Hurlstone Agricultural High School (SSD 17_8614): Response to Submissions

This letter and its attachments outline the proponent's response to the additional information requested by the Department of Planning and Environment (DP&E) in the letter dated 5 March 2018, as well as other agencies.

Response to Agency Submissions

Figure 7 – Pre Development Indicative Depths of Inundation & 1% AEP Flood Contours

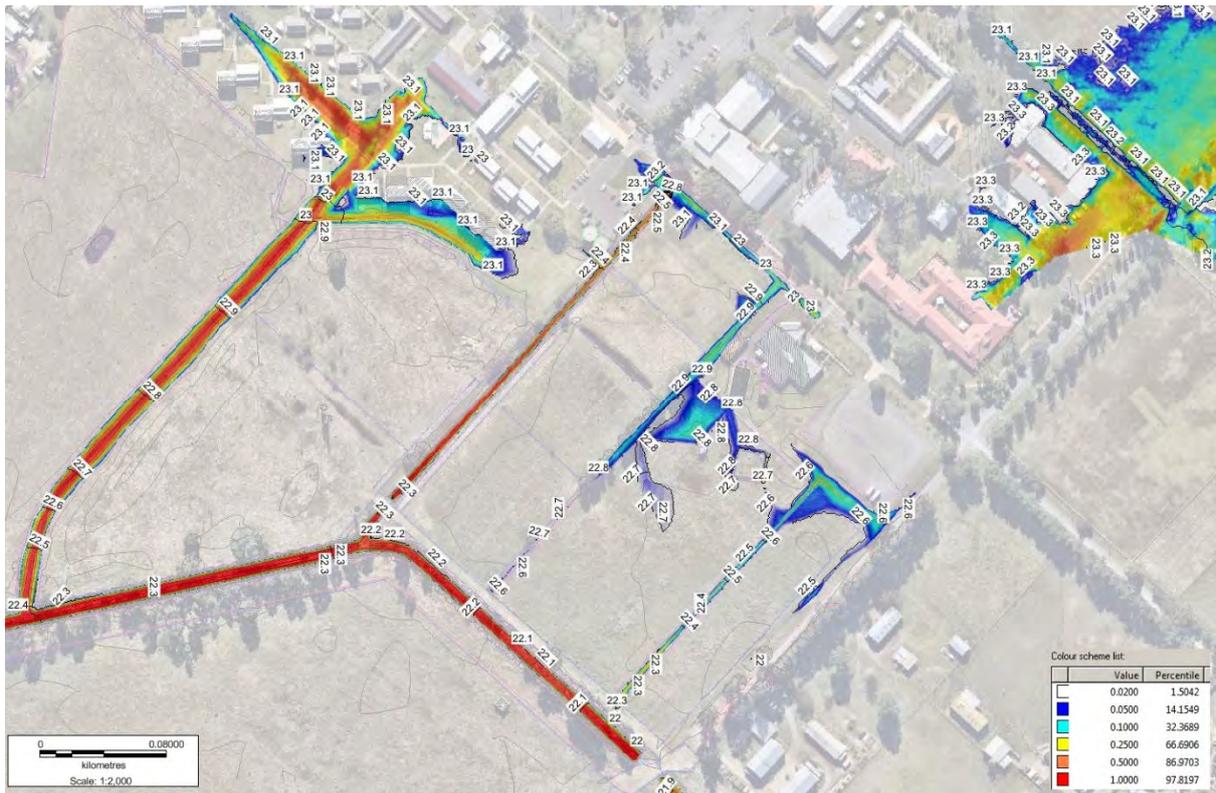
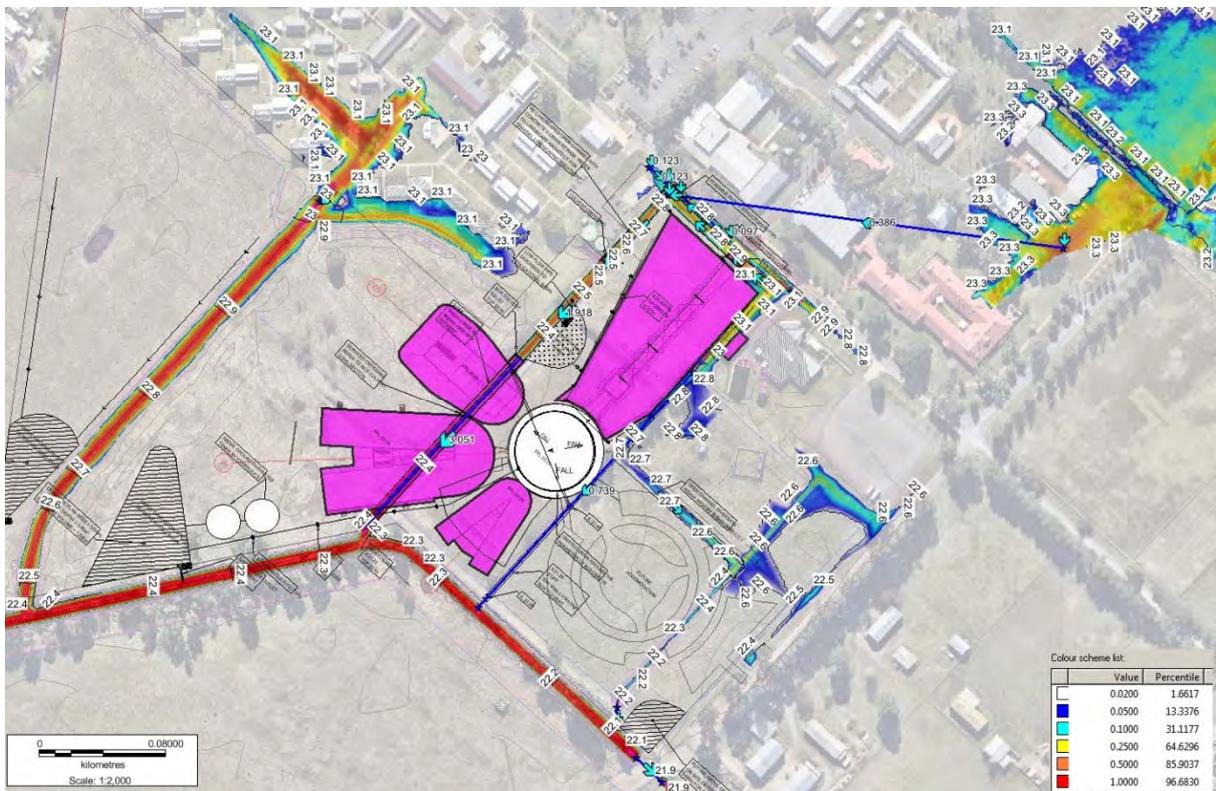
Issues Raised by Agency Submissions		Proponent's Response
	<p>especially a concern as the channels are piped underneath the buildings on the western side which provides an additional hazard.</p> <p>(b) Figure 7 (Pre-development) does not show the existing pipe from the university as shown in Figure 6. Clarification is sought on whether the pipe was modelled in the pre-development case. As the pipe is existing it should be include in the pre-development case.</p> <p>(c) The afflux map presented in Figure 9 is confusing to read. A legend should be on the figure as Well as a simplification of how the afflux is presented. The text boxes with impact are confusing as to the exact location and the extent of the flood is hidden by these text boxes as well.</p> <p>(d) The assessment should provide a sensitivity analyses to determine the potential impacts from climate change on flooding behaviour, as per the flooding requirements issued in the SEARS for the proposal.</p>	<p>considered necessary given the inland location of the property and distance from the coastline.</p>
